BR/213/21/HH

12-14 The Steyne Bognor Regis PO21 1TP

Erection of front porch extension, installation of first floor double balcony and external facade alterations (This application may affect the character and appearance of The Steyne, Bognor Conservation Area)

DRAWING: Front Facade Alterations			
TITLE: Proposed Plans and Elevations			
SCALE AT A1: 1 : 50	DATE: Issue Date	DRAWN: EL	CHECKED: AP
PROJECT NO: The Styn	DRAWING NO: WLD-010-21-05	REVISION:

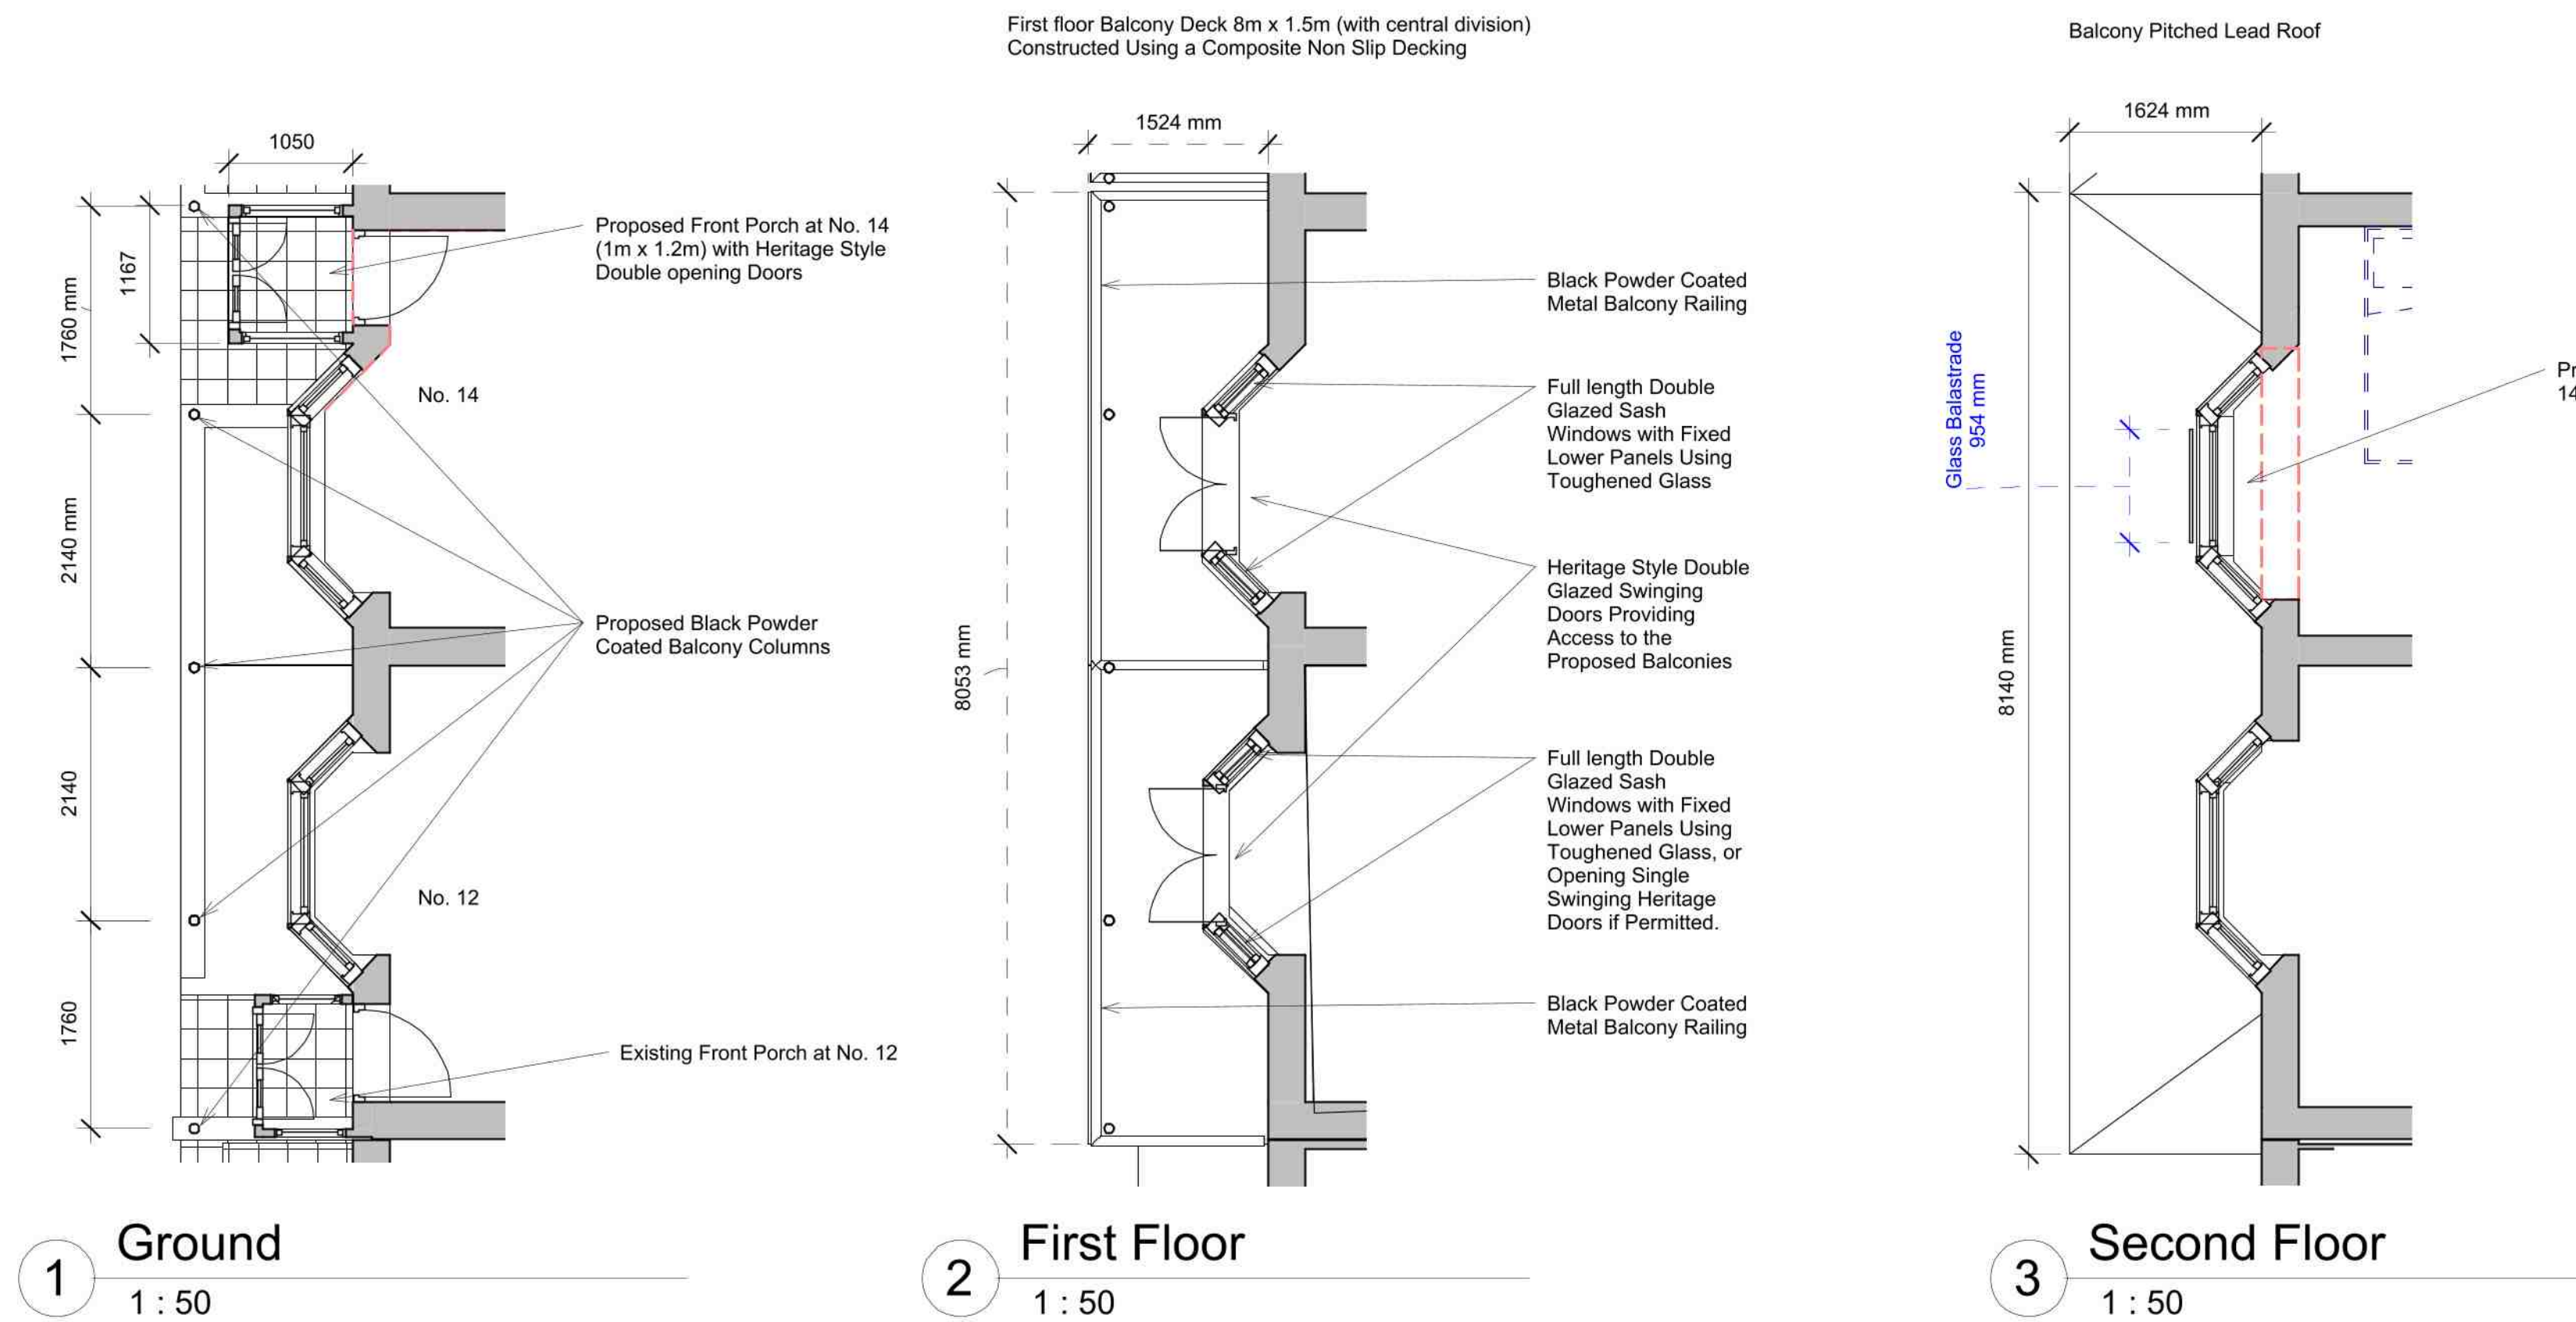
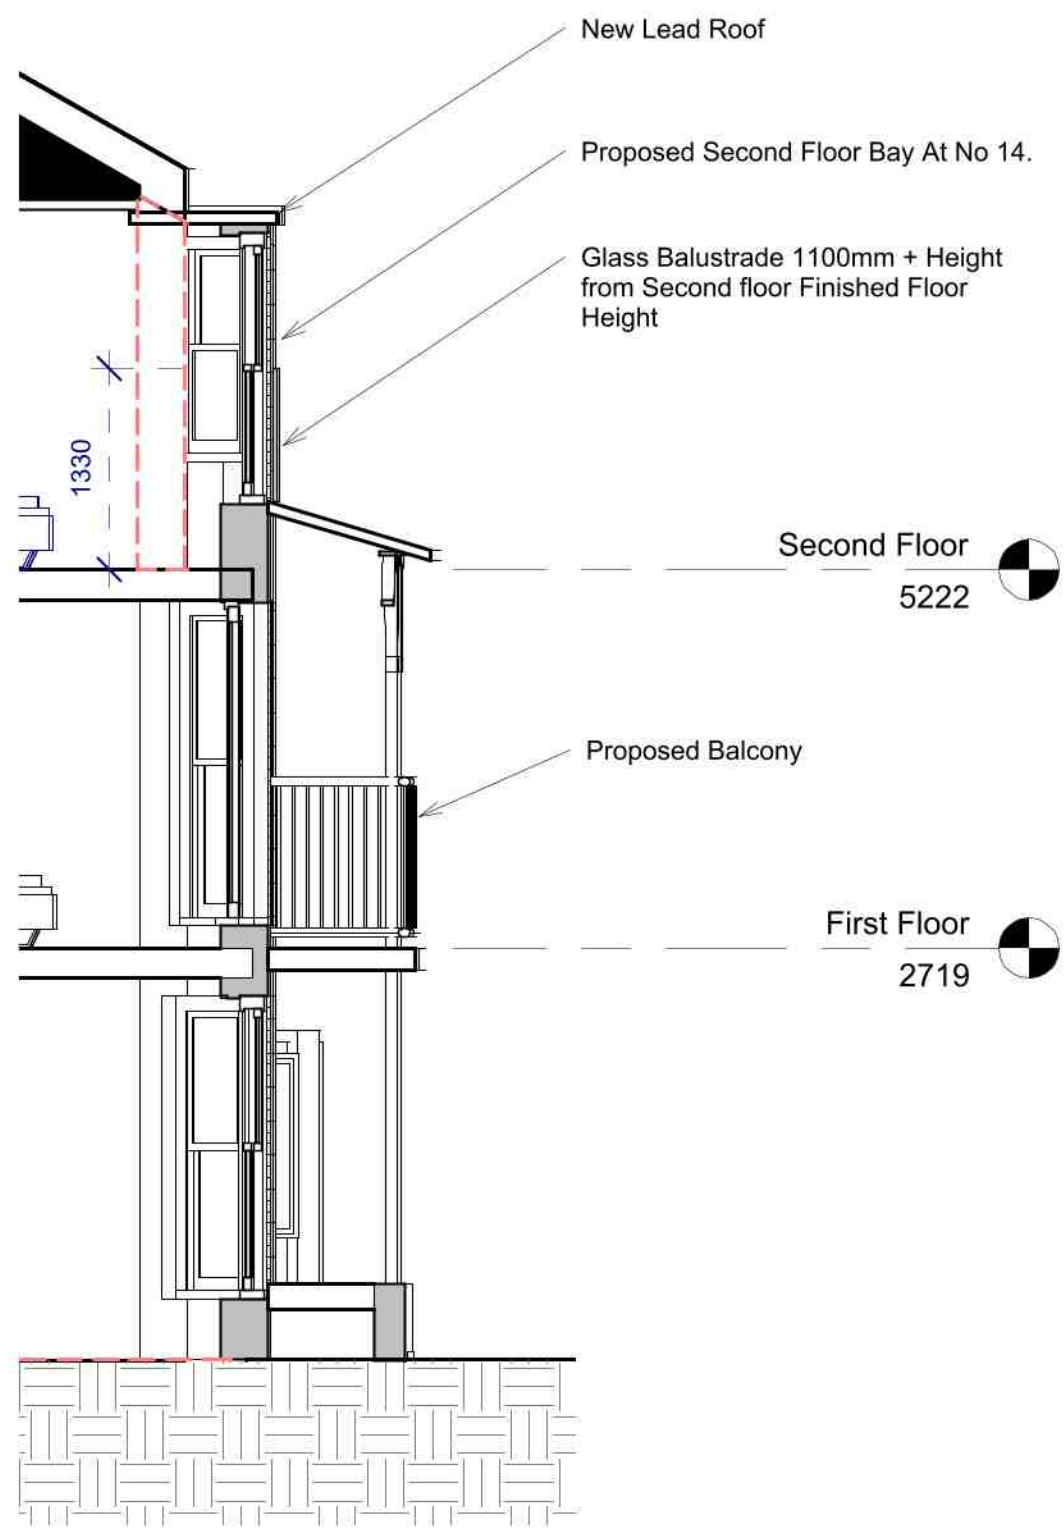
The proposal is for the erection of a front porch extension, installation of first floor double balcony and external facade alterations to both buildings. The proposed front balconies will complement those already present within the square and will ensure that they have a neutral impact upon the street scene. The introduction of the balconies will require further external alterations and it is recommended that all of the windows are sash windows as opposed to single doors as suggested as an alternative option on the plans provided. I am also of the opinion that replacing the casement of number 14 and altering the front elevation to introduce an additional bay window will be a positive element of the scheme. The result will be that both houses will look like a mirror image of the other.

It is not clear what materials the new windows will be constructed from and it is suggested that, given their location, that all new windows and doors should be of painted timber and that the windows are vertically sliding sashes. Details of the windows and doors could be provided to the council by way of condition if you are minded to approve the application. This could include any paint colours/treatments to be used

Subject to the use of appropriate windows/doors, materials and finishes, the application is considered to not cause harm to the significance of the heritage assets or their setting. As a consequence, it should be determined in accordance with the relevant policies within the Development Plan, along with these comments. You will also need to take into account the contents of the Planning (Listed Buildings and Conservation Areas) Act 1990 (as amended).
